Application No: FG/206/21/PD
Site Address: 9 Ocean Parade Ferring BN12 5QG
Description of works: Notification for Prior Approval under Schedule 2 Part 3 Class MA of the Town & Country Planning (General Permitted Development) (England) Order 2015 (as amended) for the change of use from retail use (Class E(a) to residential (Class C3)
- Conversion of existing retail building into 2 No. self-contained residential units.

Thank you for your internet representation made on 8th December 2021 which has been recorded as an objection with the comments as follows:

Ferring Parish Council object to this application for Prior Approval under Schedule 2 Part 3 Class MA of the Town & Country Planning (General Permitted Development) (England) Order 2015 (as amended) for the change of use from retail use (Class E(a) to residential (Class C3).

1 PROPOSED SITE PLAN
2002 Scale: 1 : 200

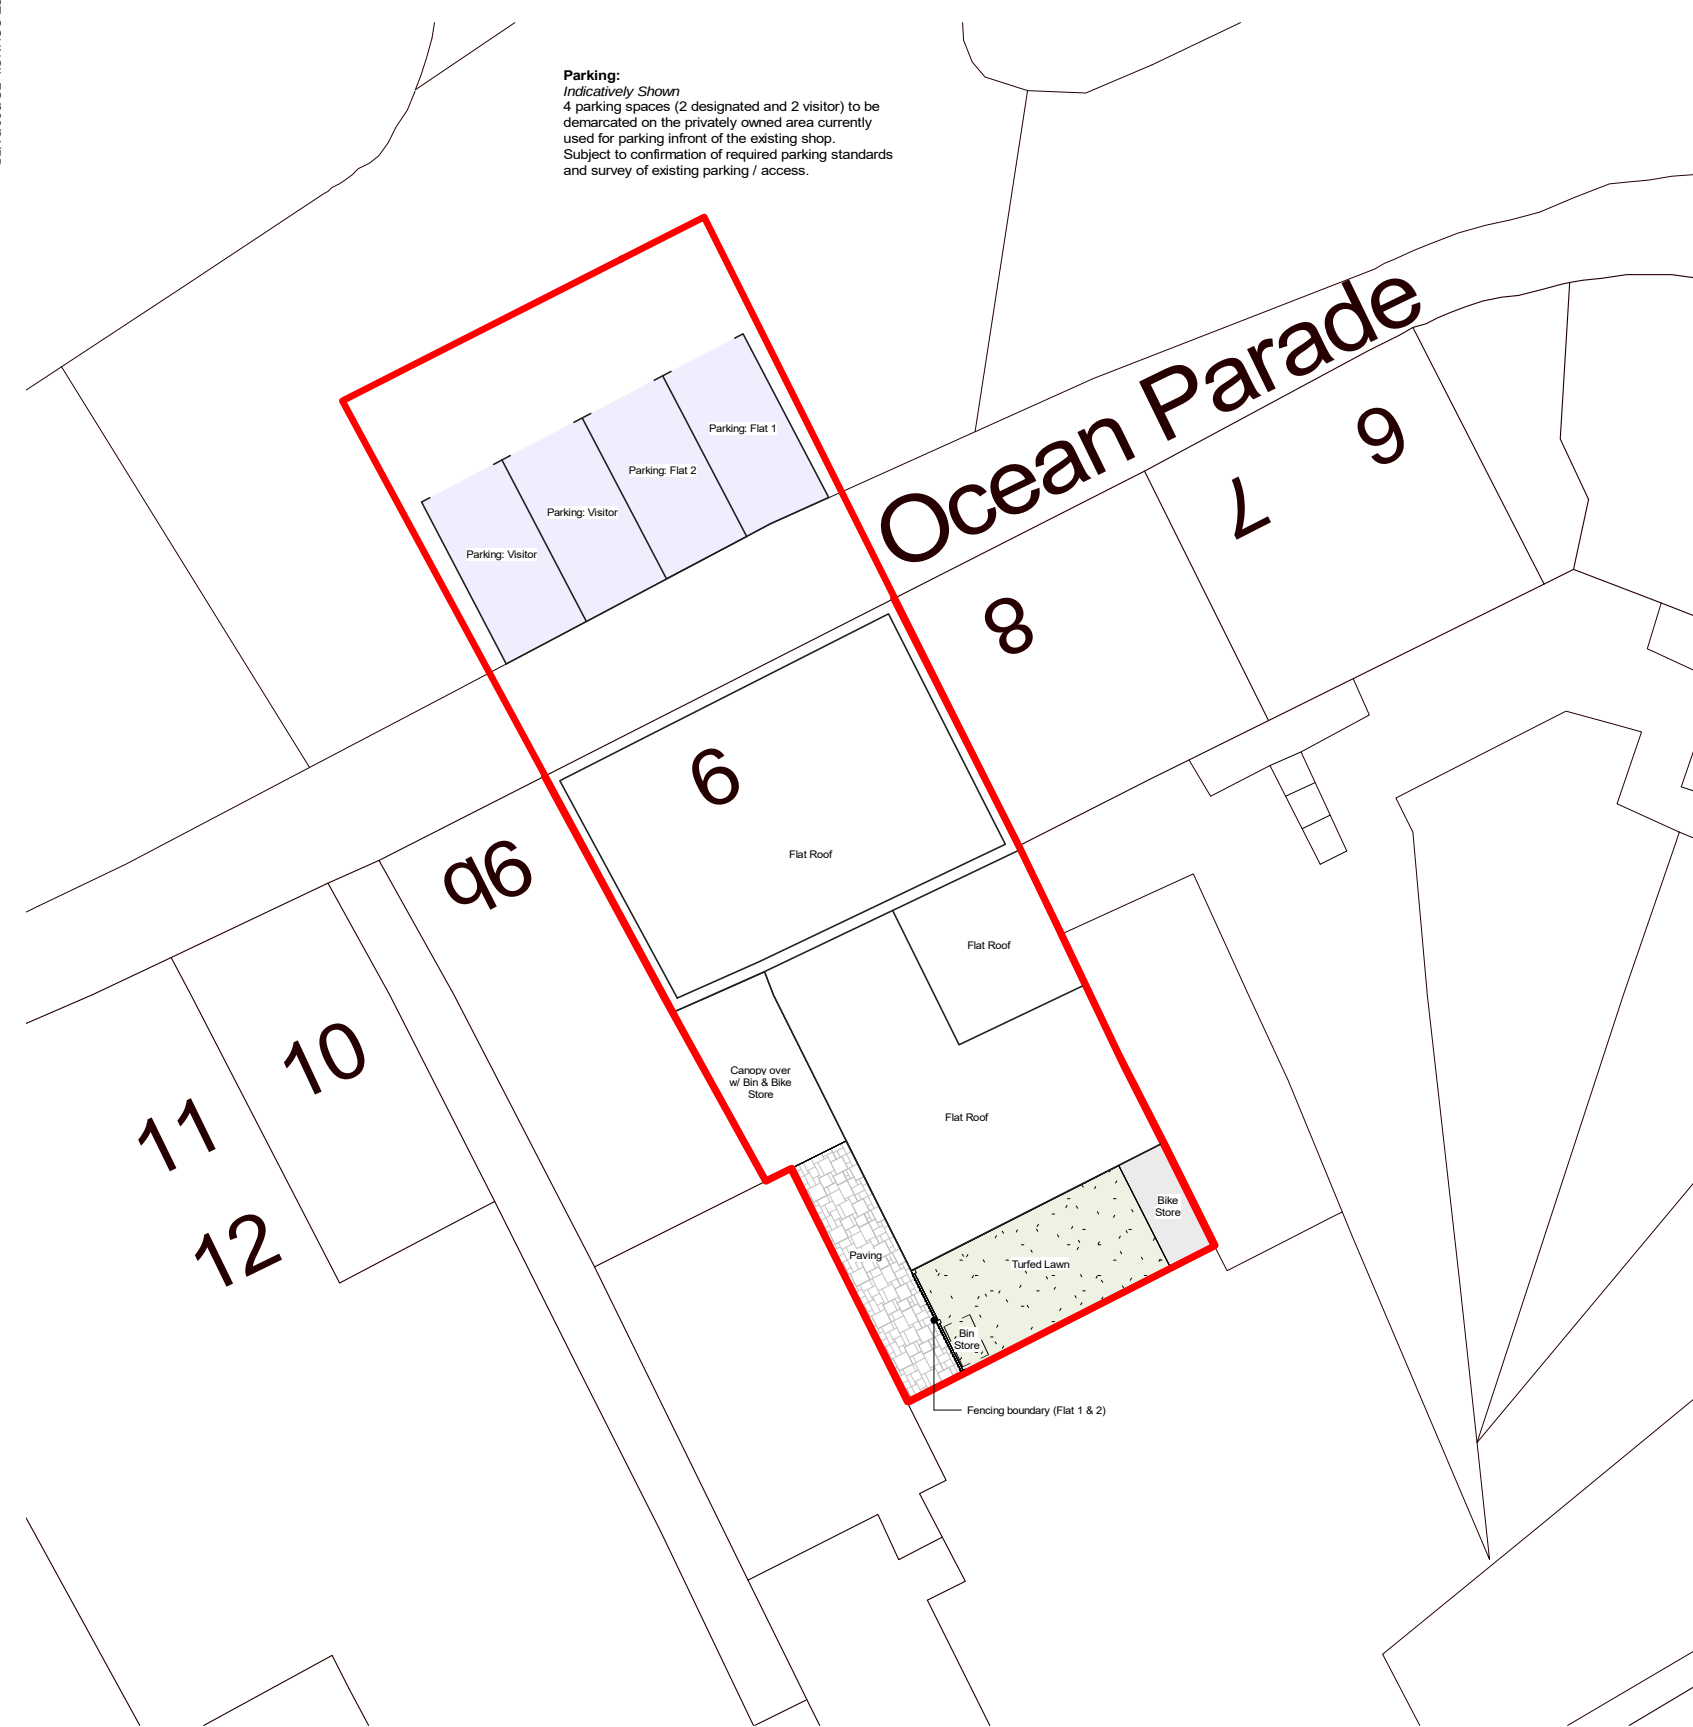
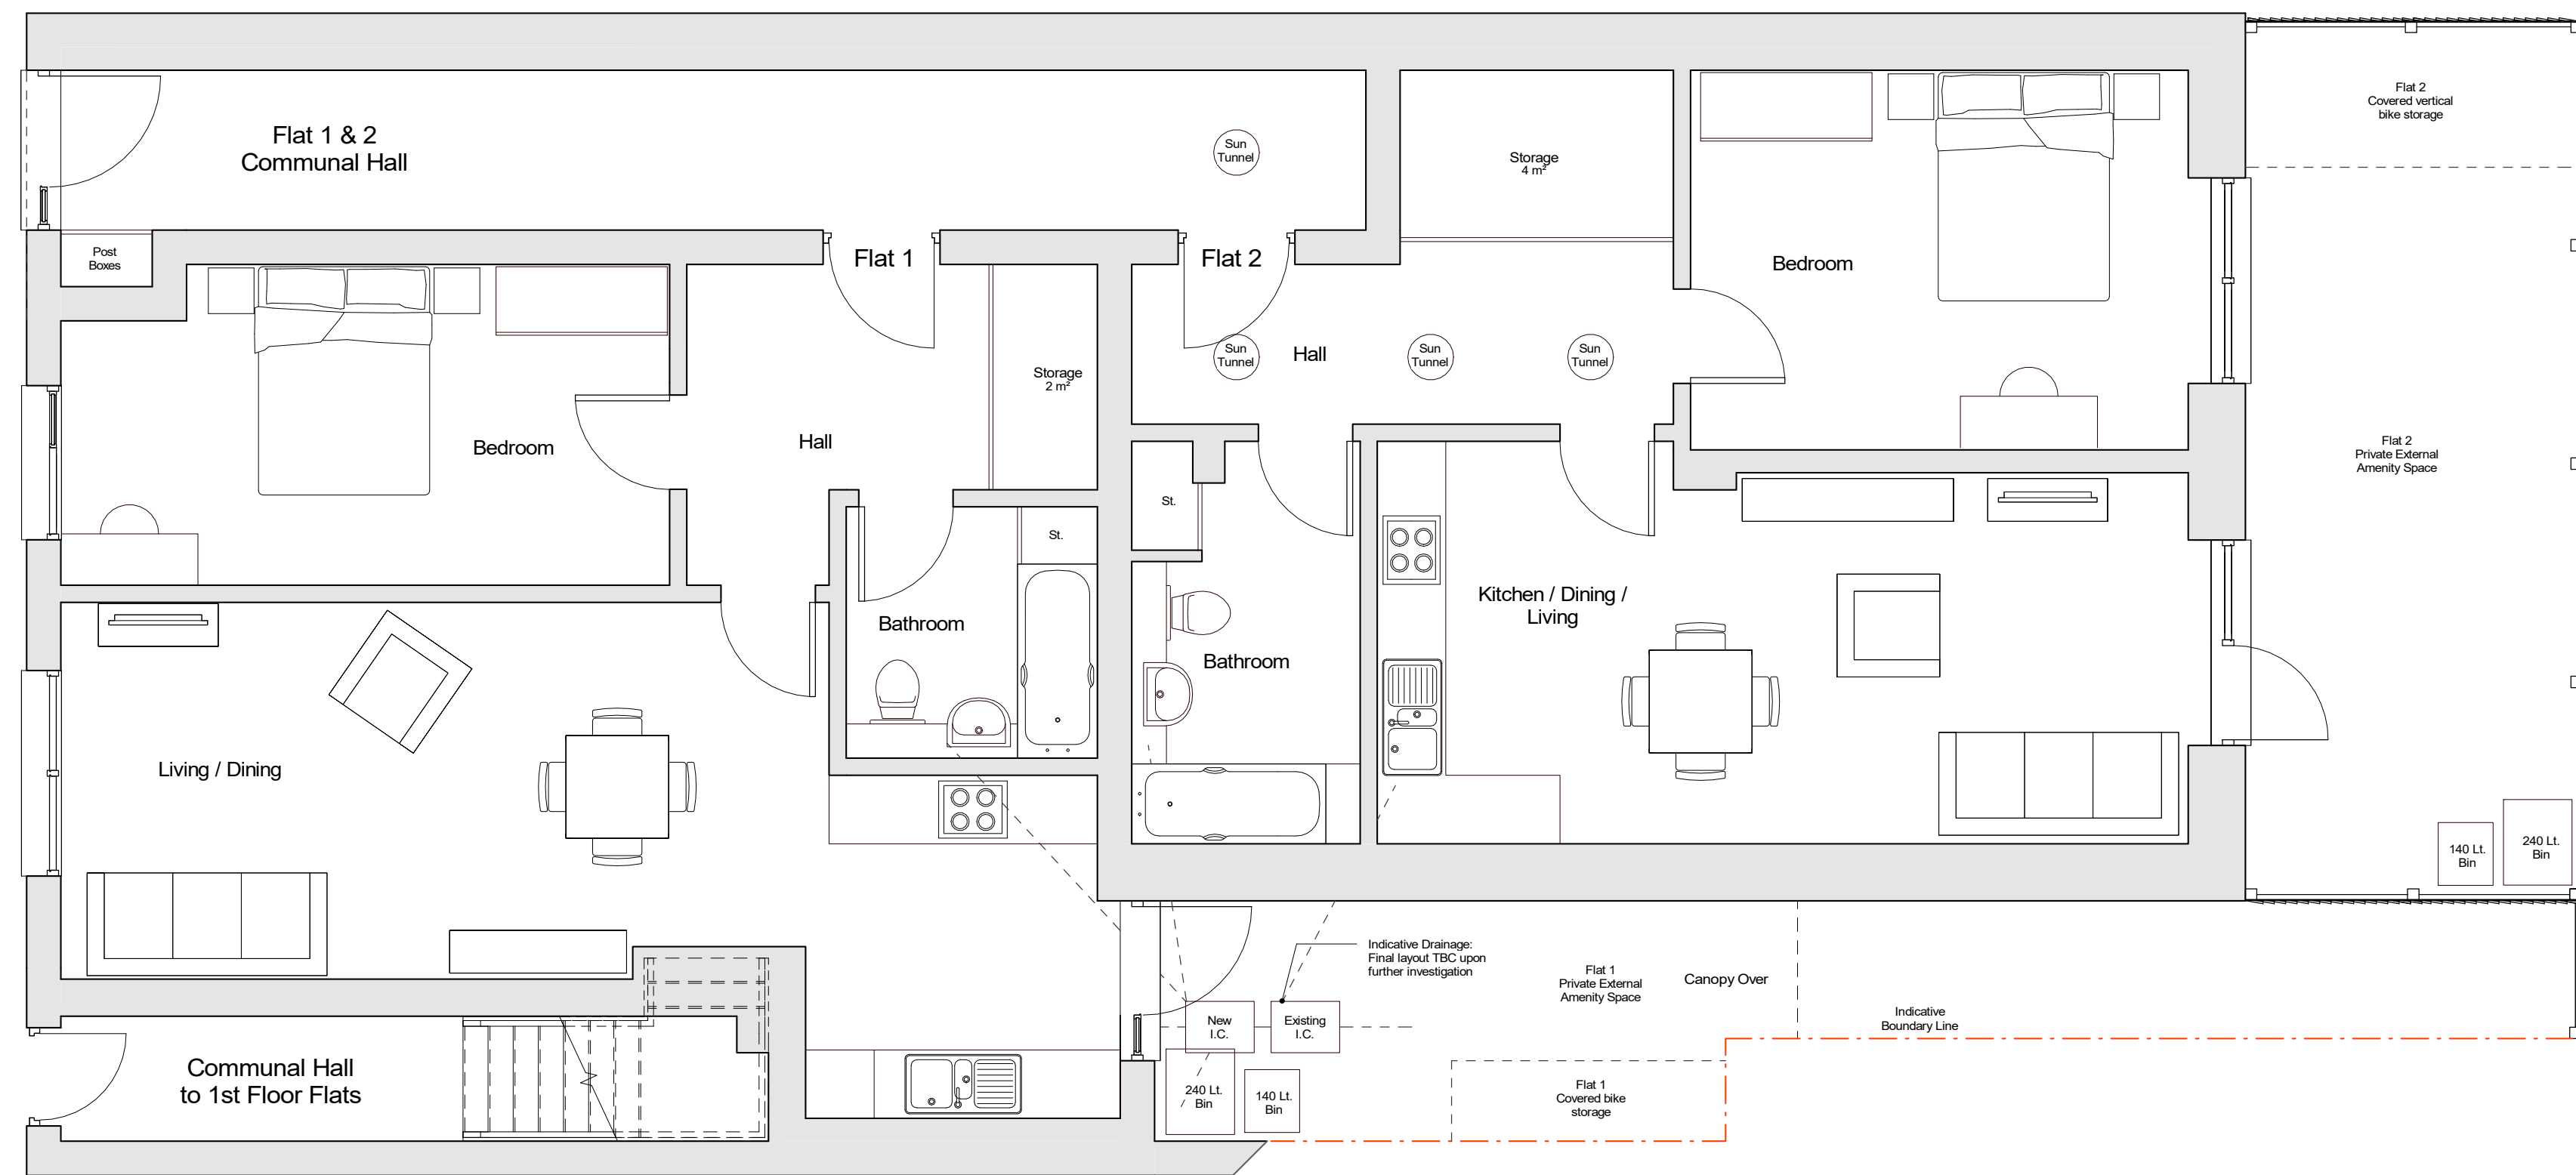
We would bring to the attention of the Authority that there does not appear to be any provision for cycle parking or for electric vehicle charging in the plans.

- the four defined parking spaces and access are maintained as such.
- unhindered public access is maintained across the existing pathway in front of the residential units maintaining freedom of passage as currently available. This is particularly important for highway / pedestrian safety and for ease of access to other shops / businesses in the parade in support of their ongoing viability.
